December 27, 2025

RE: RESPONSE TO COMMENTS DATED September 22, 2025

**GRADING AND DRAINAGE PLAN**  
2103 LOS LUCEROS ROAD NW  
ADRIAN OGLESBY

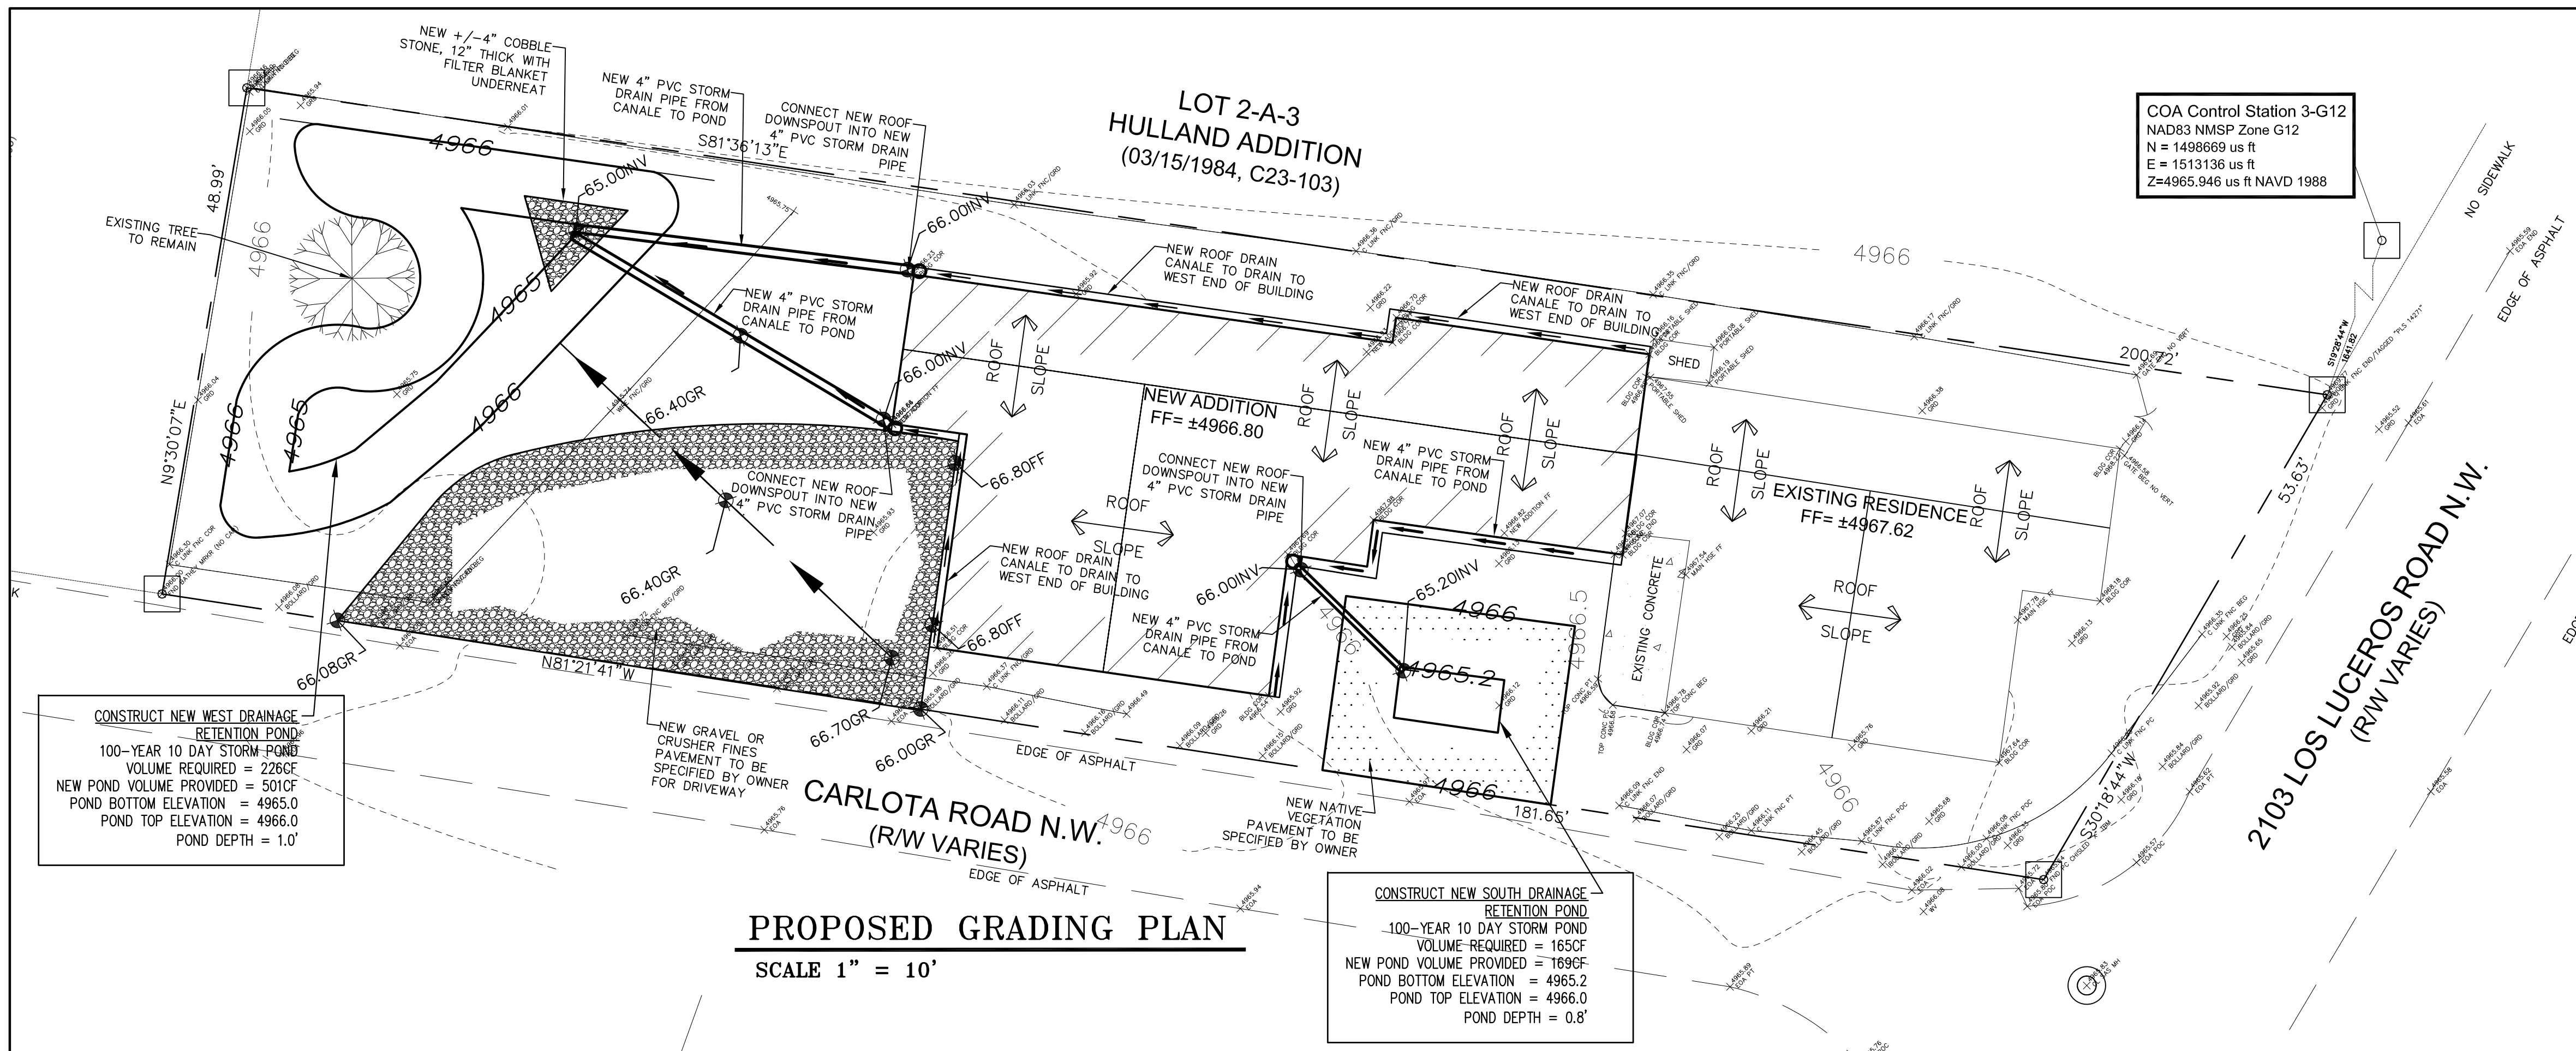
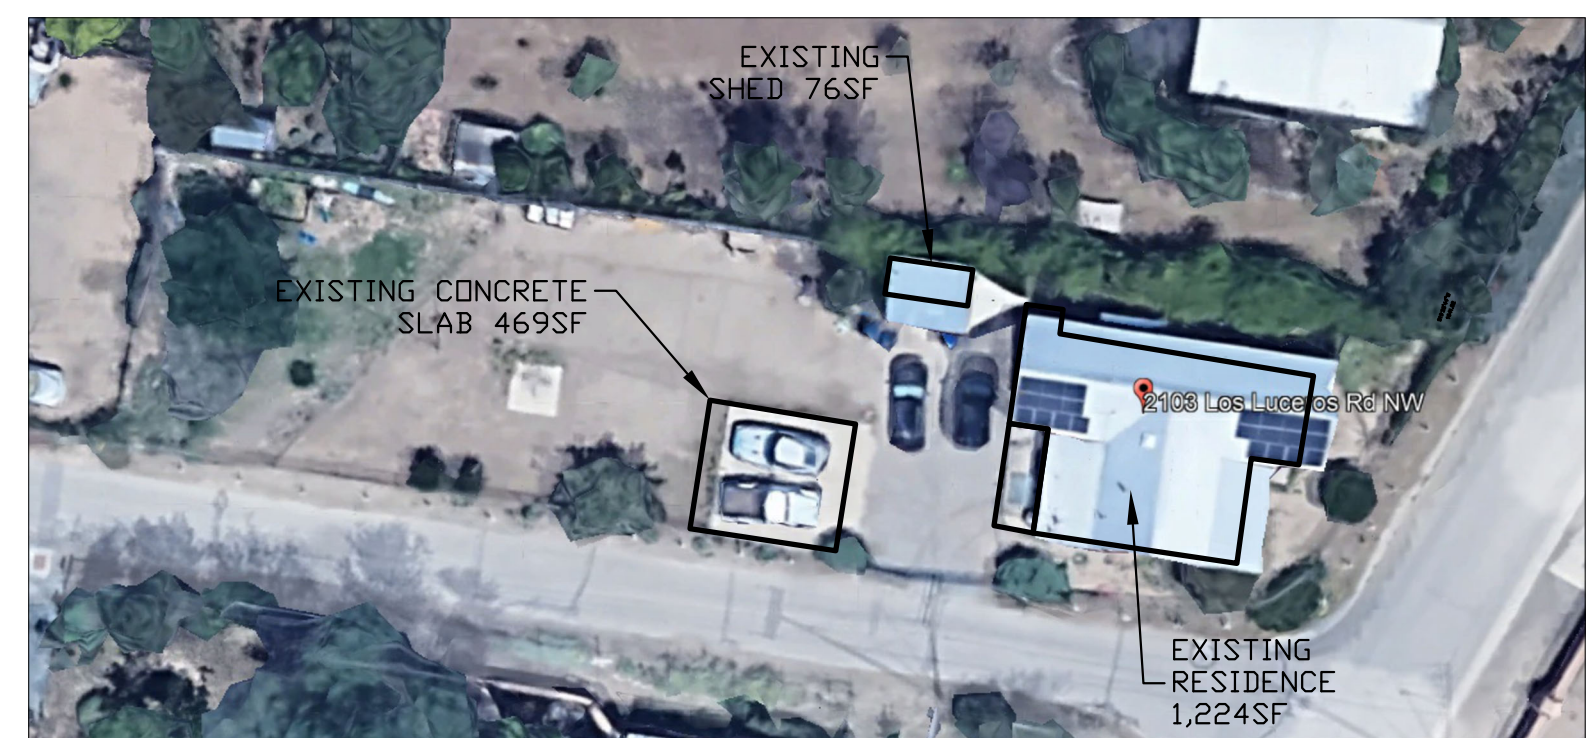
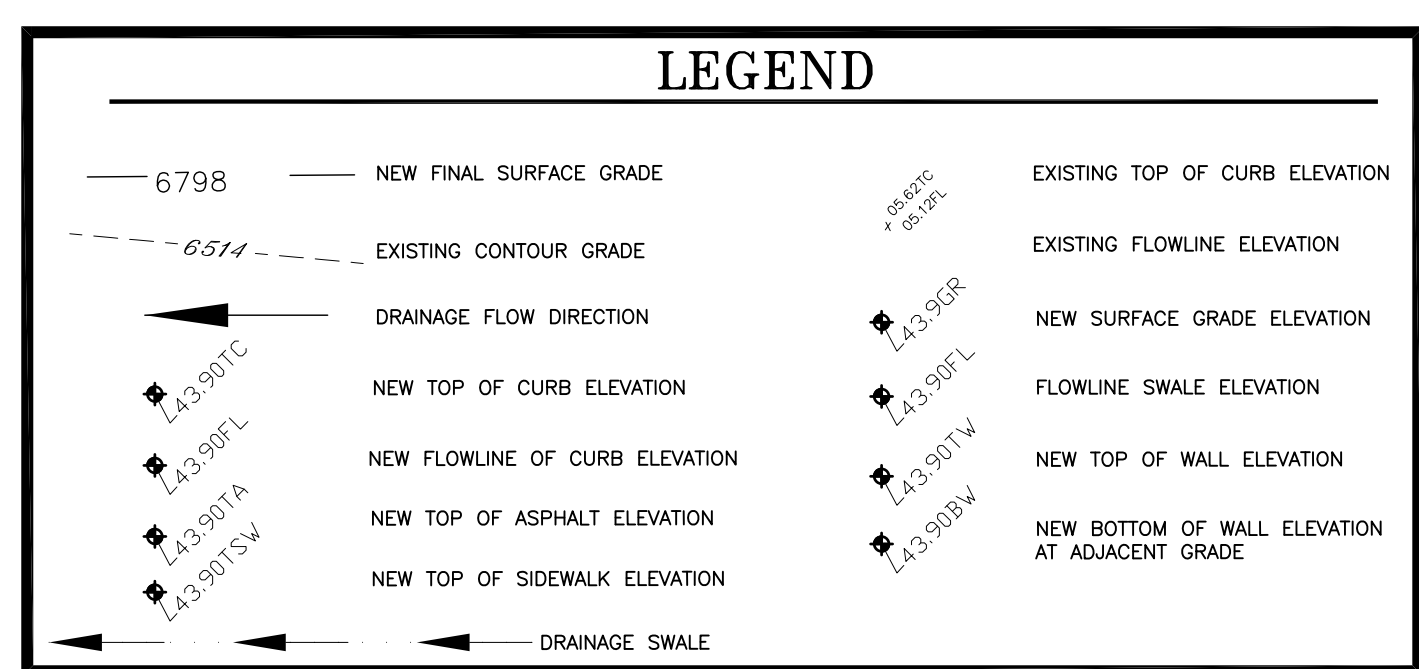
1. See the attached approved DHO waiver #PR-2019-002186 dated December 3, 2025 that does not require curb/gutter and sidewalk.
2. The Benchmark information is now shown on the drawing, COA Control Station 3-G12 NAD83 with Elevation = 4965.946 us ft NAVD 1988 for establishing the contour information.
3. The pond bottom area, top area are now shown as dashed contour lines along with a note regarding the pond depth have now been included.
4. As we discussed and agreed per our telephone call back in September, the site drainage has been designed to contain the 100 year – 10 day storm for the proposed impervious conditions, there will no impact to downstream conditions.
